Our reference: 7722617
Contact: Gavin Cherry
Telephone: (02) 4732 8125

**Re: Proposed State Significant Development - Benedict Penrith
Resource Recovery Facility (SSD 7733)**
Property: Nos. 46-48 Peachtree Road Penrith

01 PROPOSED SITE PLAN
SCALE 1:500

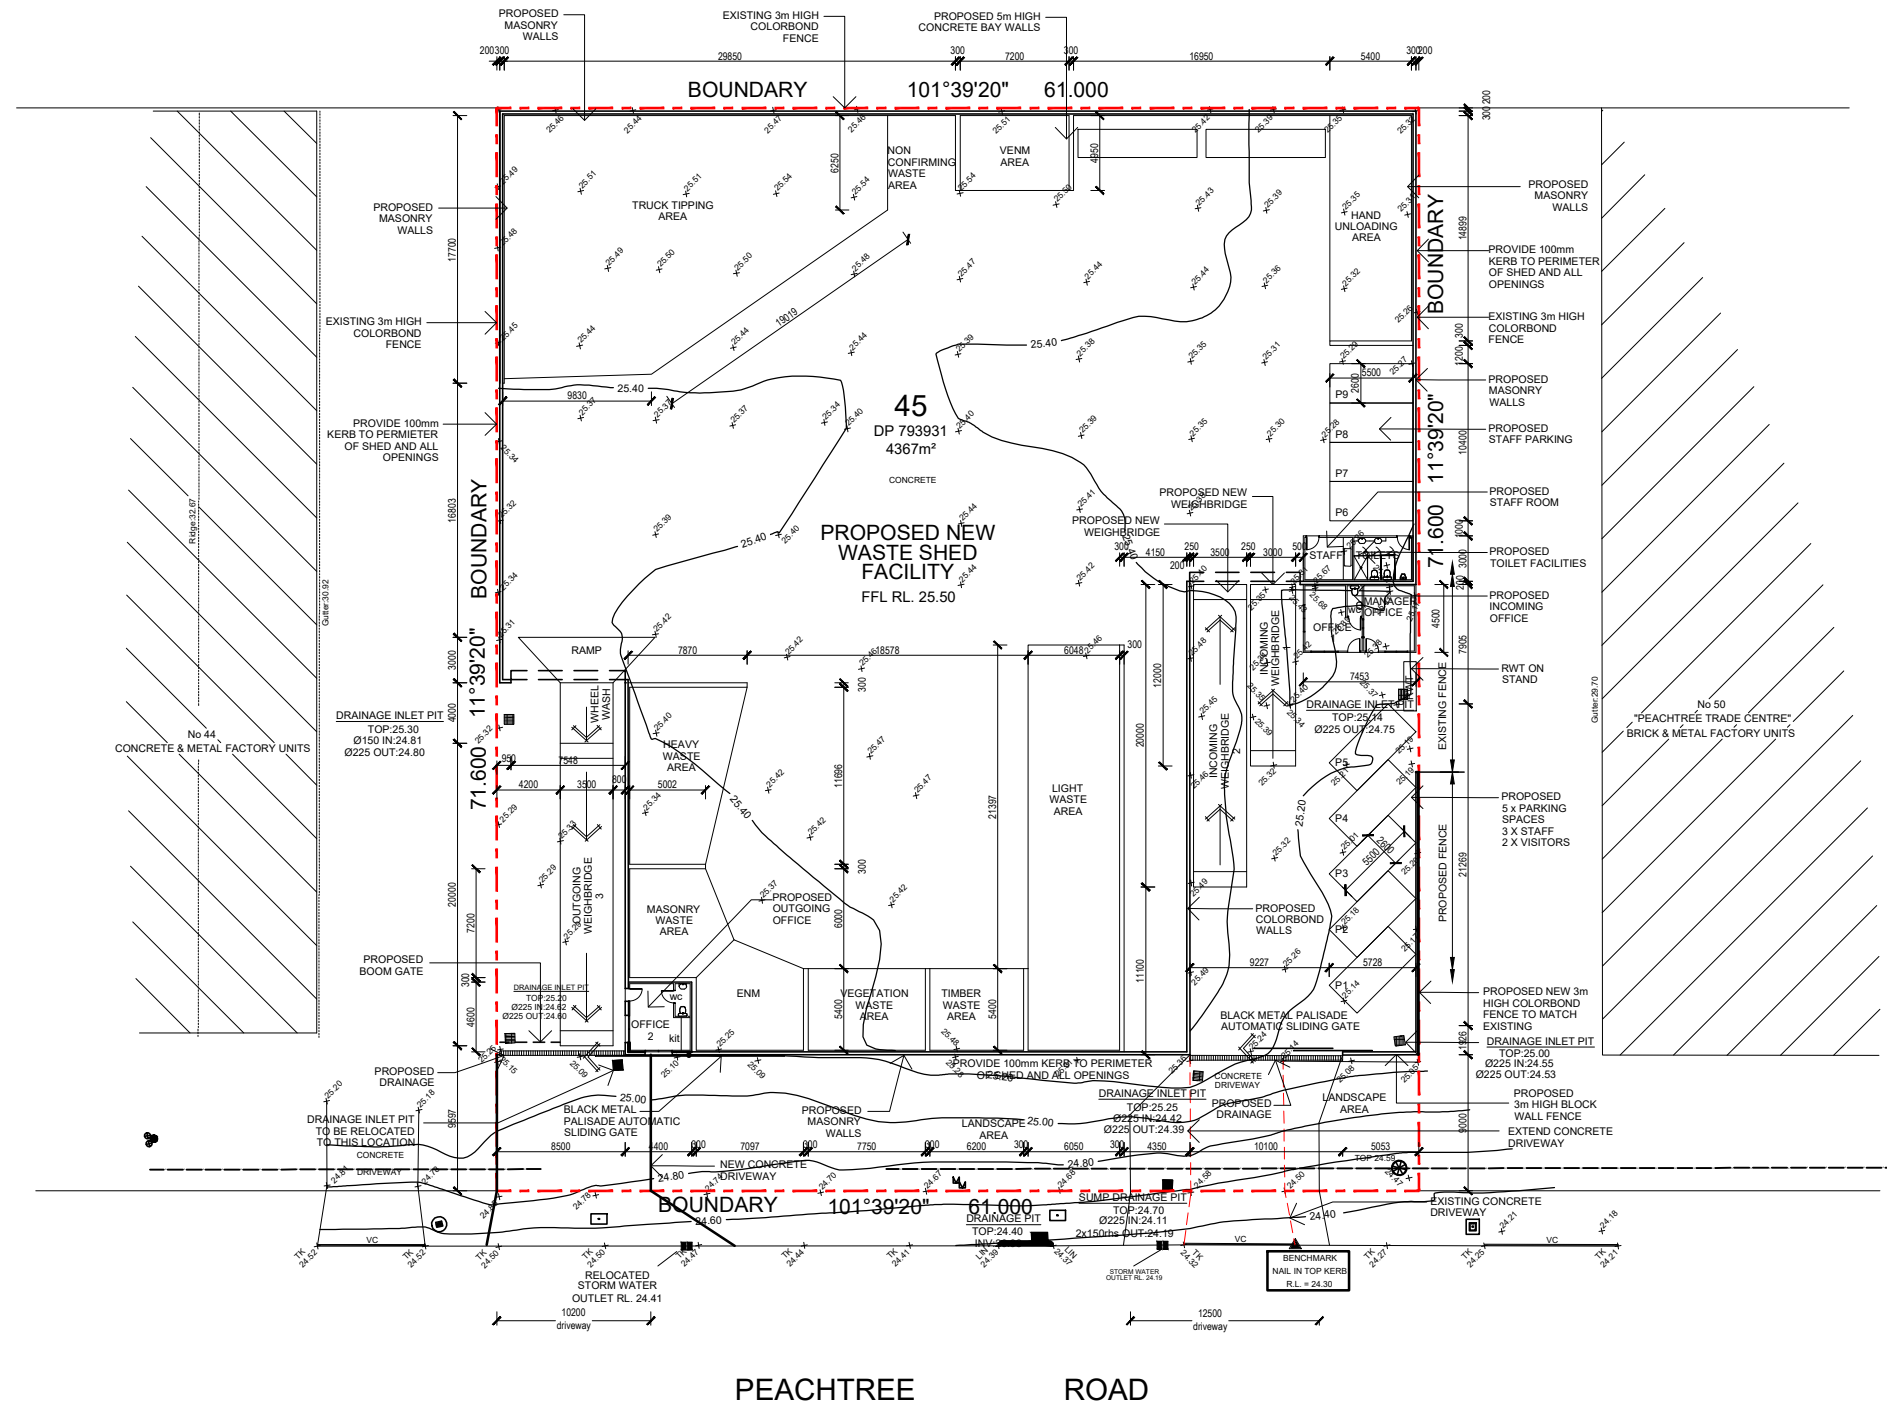
- The Traffic Impact Assessment mentions the provision of truck parking onsite, but it is not clearly shown on the plans provided unless it is referring to the truck manoeuvring area (which cannot be counted as a truck parking area).

Landscape plan
 Penrith Waste Recycling and Transfer Facility
 Response to Submissions
 Appendix J

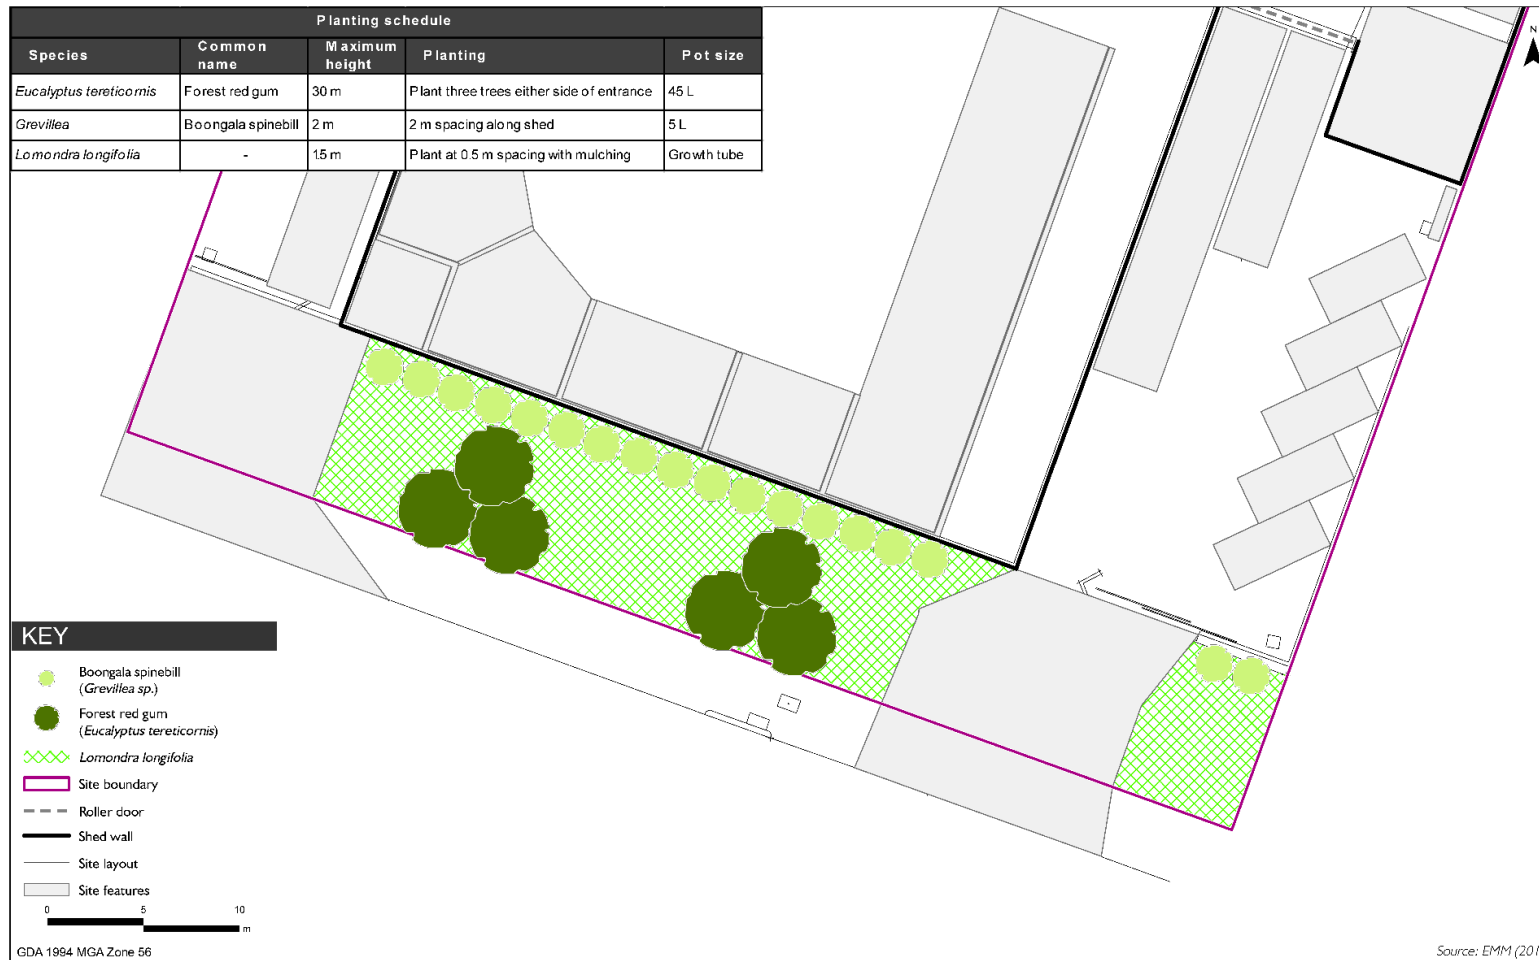
- The proposed landscape plan and planting detail is inadequate. The indicated 'lomondra' and 2 x native trees is inadequate planting to suitably treat the existing streetscape in front of the exposed building and setback east of the driveway. An embellished landscape plan is to be provided which outlines embellishment of the front setback zone with specific species, pot size and quantities including a mix of tree and shrub plantings. At a minimum 3 trees across the frontage should be proposed with understorey shrub landscaping to supplement. This could be addressed through conditions of consent if the application was supported.
